From:
Sent: 13 May 2024 17:51
To: DCAdmin
Subject: RE: 8, Westfield Court, Mirfield, WF14 9PT 2024/90637

From:
Sent: 19 April 2024 17:00
To: dc.admin@kirklees.gov.uk
Subject: 8, Westfield Court, Mirfield, WF14 9PT 2024/90637

STREET PLAN  
1:500

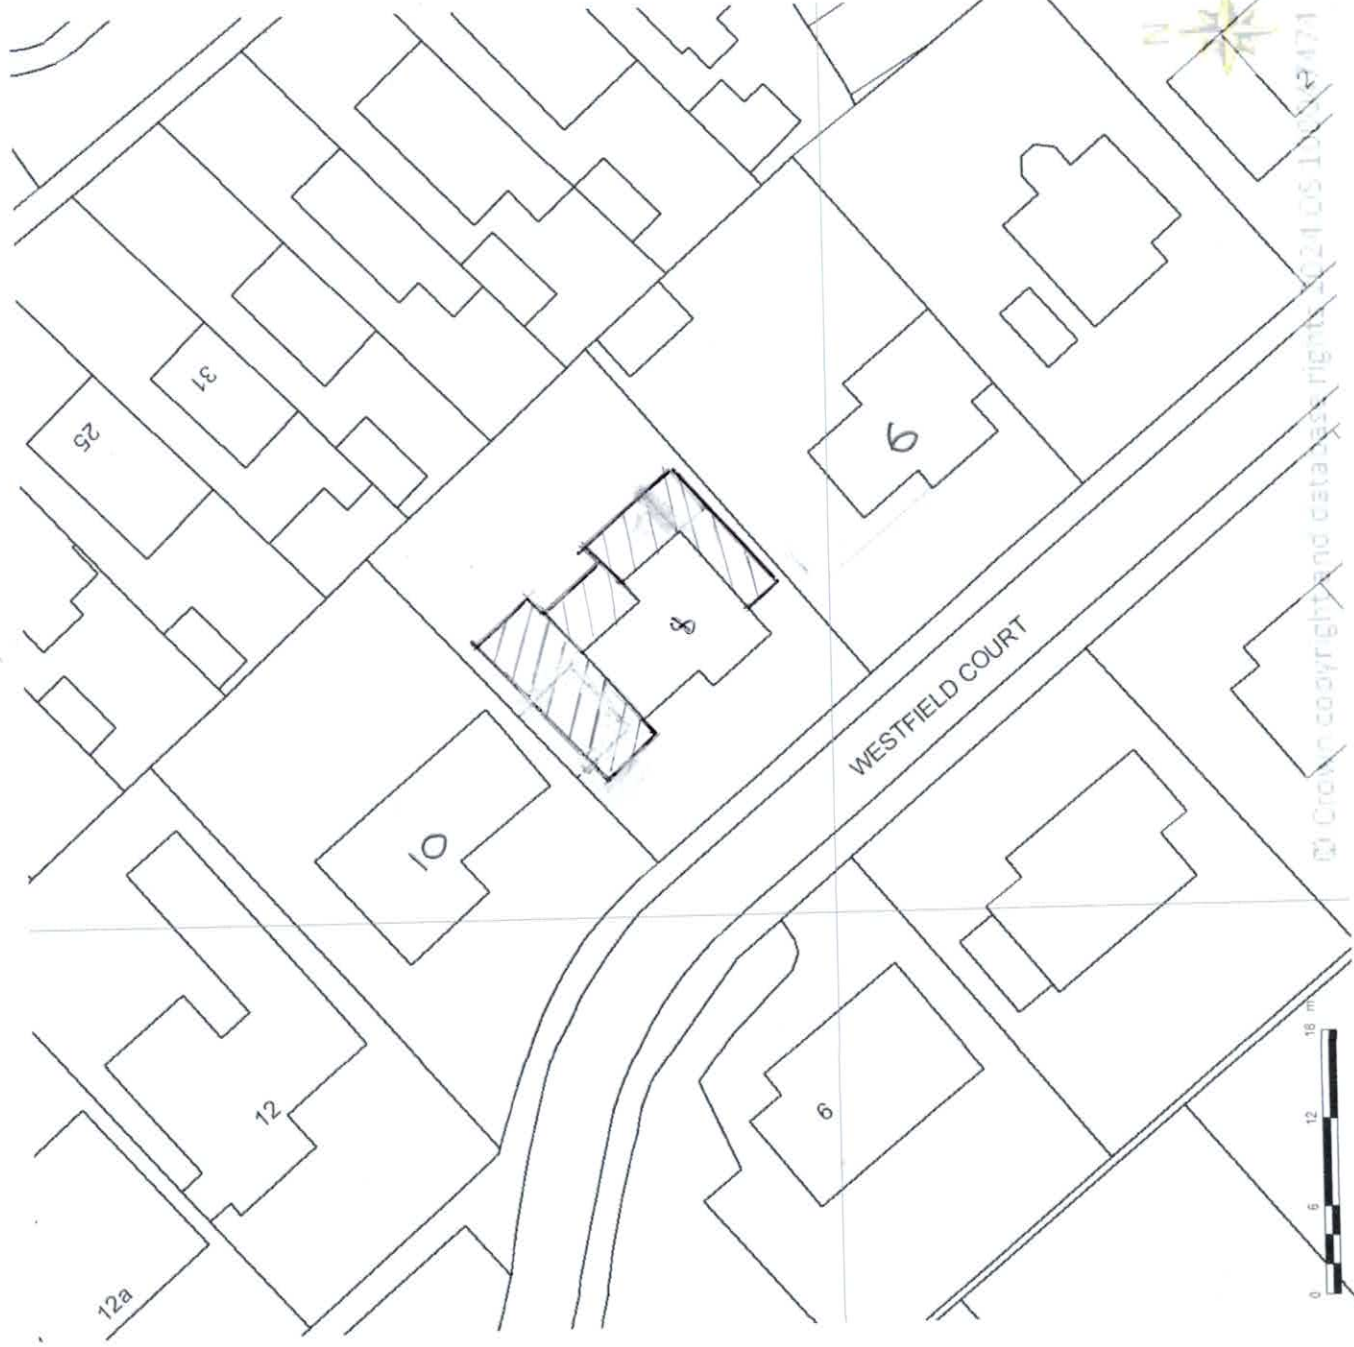
Part of the planning application area is not owned by the applicant but is owned by the adjoining owner at house no 10; therefore Section 11 of the application is incorrect. The existing ground floor plan no. 2024/442/02 is incorrect as the boundary with no. 10 is shown as a straight line from the North- West elevation of the garage wall to the highway. The actual property boundary kicks back in, in front of the existing garage by approximately 40 cm. This property boundary with house no 10 and the existing stone wall must remain. This wall has been in place for over 20

years and the land used exclusively, for the whole of this period, by no 10. The same incorrect property line is shown on the proposed site plan. Consideration both in terms of design and also in terms the engineering treatment of the retaining wall of the garage and its relationship with the stone wall from no 10 must be detailed and agreed with the planners and no 10 before commencement of the works.
